**Consultation Response from KC,
Lead Local Flood Authority**

2025/91542 Land at, Highmoor Lane, Hartshead Moor, Cleckheaton, BD19 6LW

Erection of 40 dwellings and associated works, including formation of new vehicular access and erection of cricket netting

Date Responded: 22/07/2025.

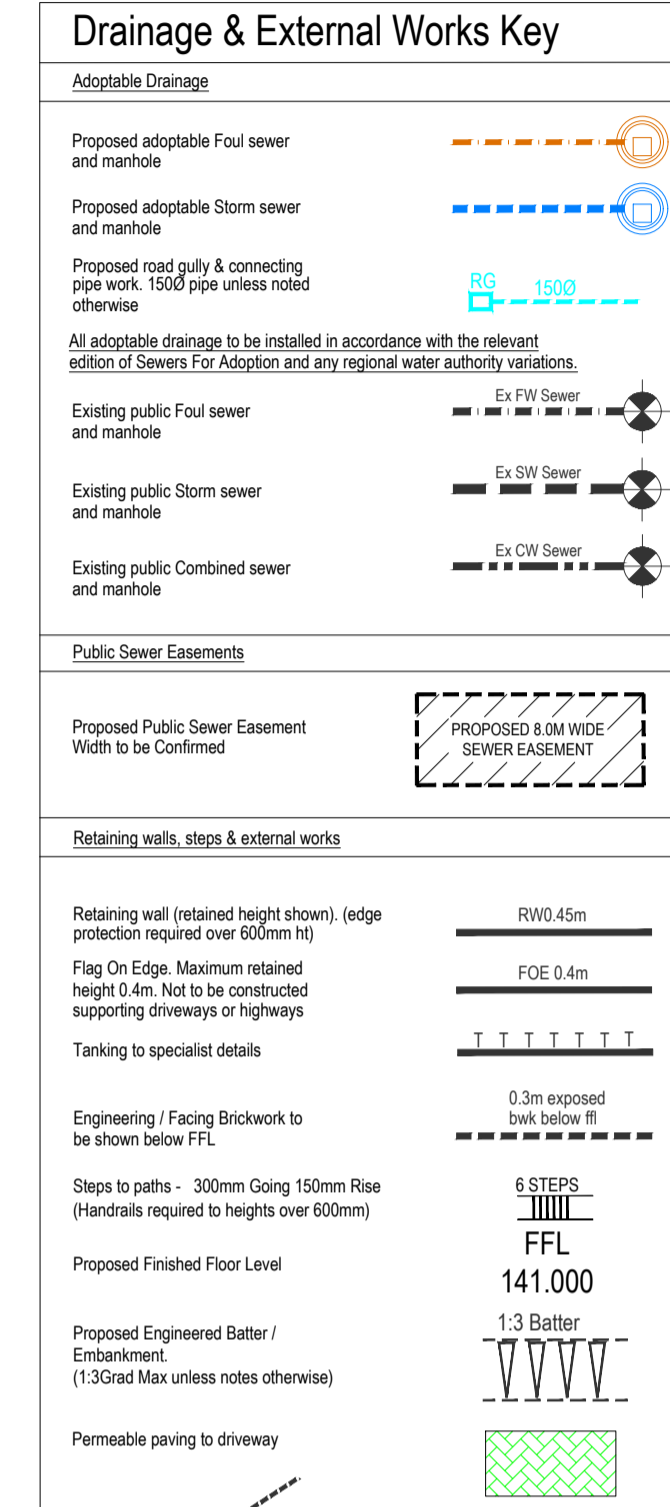
Additionally, the flood routing indicated on the *Overland Flood Flow Paths* drawing and the proposed maintenance requirements shown on the *Drainage Maintenance Plan* drawing are generally in line with the LLFA's expectations.
